**From:** George Smith  
**Sent:** 06 January 2021 10:56  
**To:** DC Support  
**Subject:** FW: 20/03347/F - The Pheasant Pluckers Inn

**From:** sibford.gower.pc@thesibfords.org.uk <sibford.gower.pc@thesibfords.org.uk>  
**Sent:** 06 January 2021 10:51  
**To:** George Smith <George.Smith@Cherwell-DC.gov.uk>  
**Cc:** Roger Mallows <clr.roger.mallows@thesibfords.org.uk>  
**Subject:** 20/03347/F - The Pheasant Pluckers Inn

**Sibford Gower Parish Council wishes to OBJECT to this application.**

PROPOSED BARN

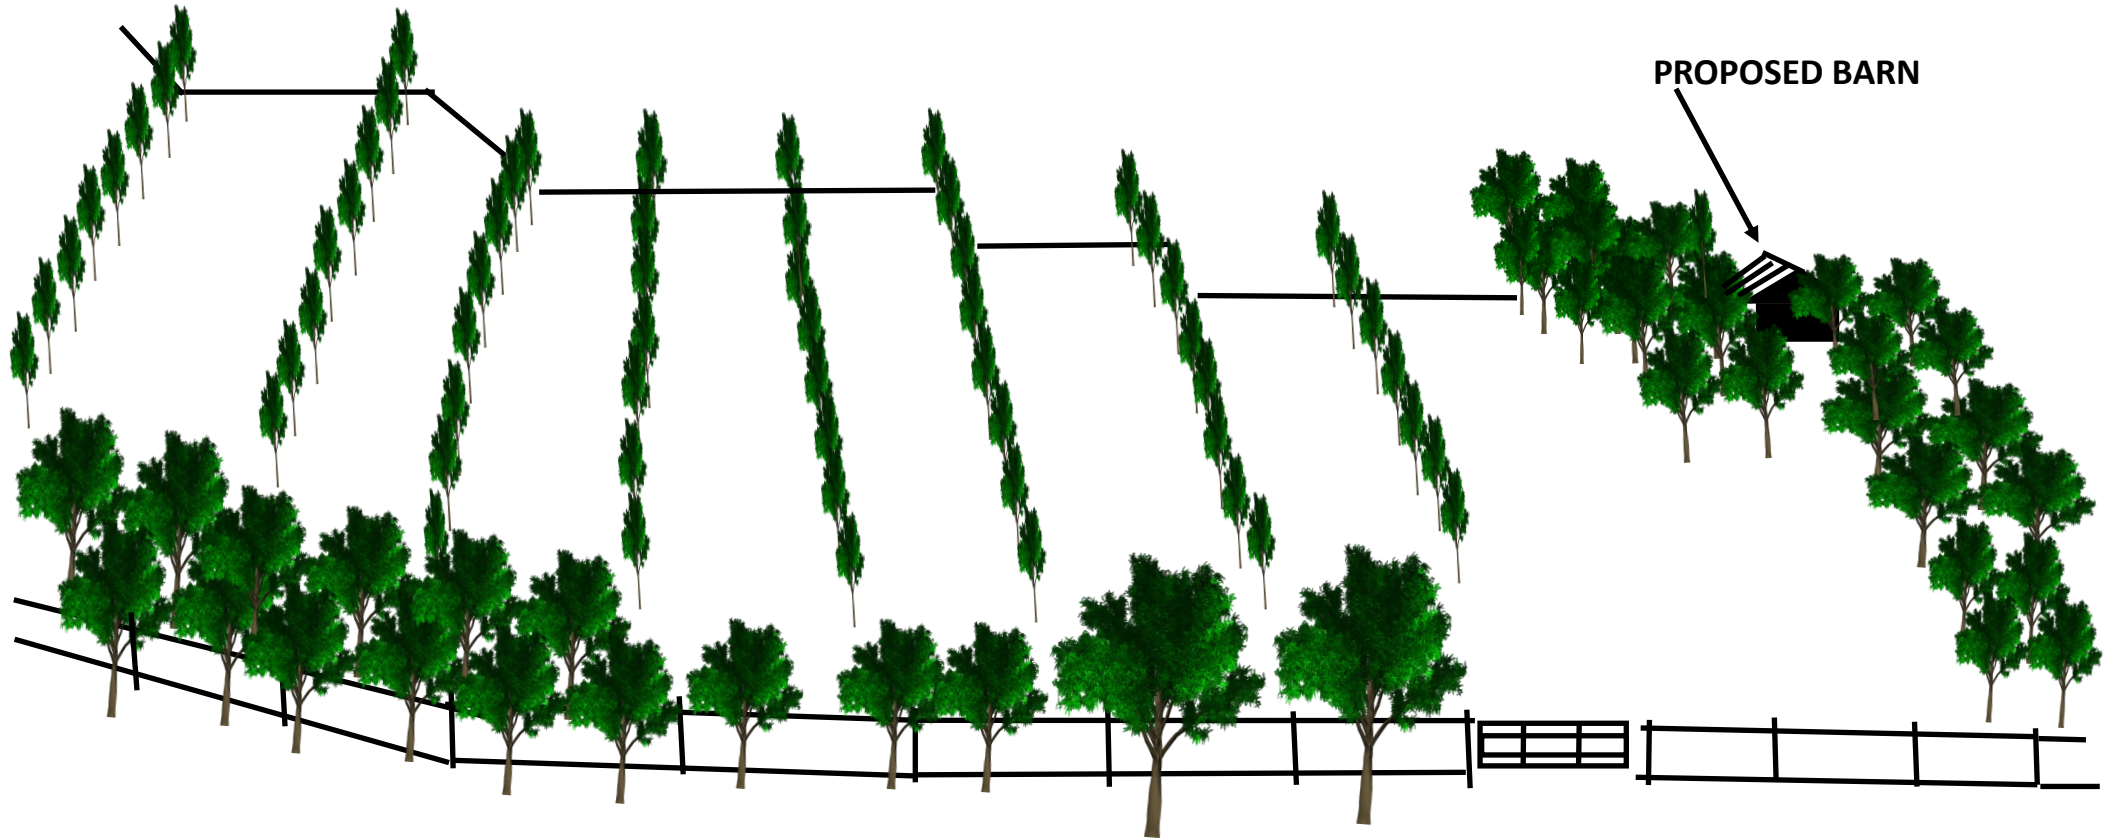
- No precedent has been identified for an earlier building in this field.
- While the identified location may be discreet from the public highway, there is a concern regarding the size and scale in relation to the anticipated maintenance requirements in relation to the modest size of the proposed vineyard.
- The erection of this building in such a prominent and sensitive location would adversely impact on the character and appearance of the valley. It is our understanding that previous planning applications in this very sensitive Sib Valley conservation area have been consistently refused for many years. The provision of any new building would set a significant precedent, rendering the area potentially vulnerable to further development.

- Although mains services (water, electricity) are not being installed, the solar lighting identified to the agricultural building will offer continuous illumination throughout the night time hours in this

“dark” location, as identified pre-2005. The provision of motion activated security lighting should be considered.
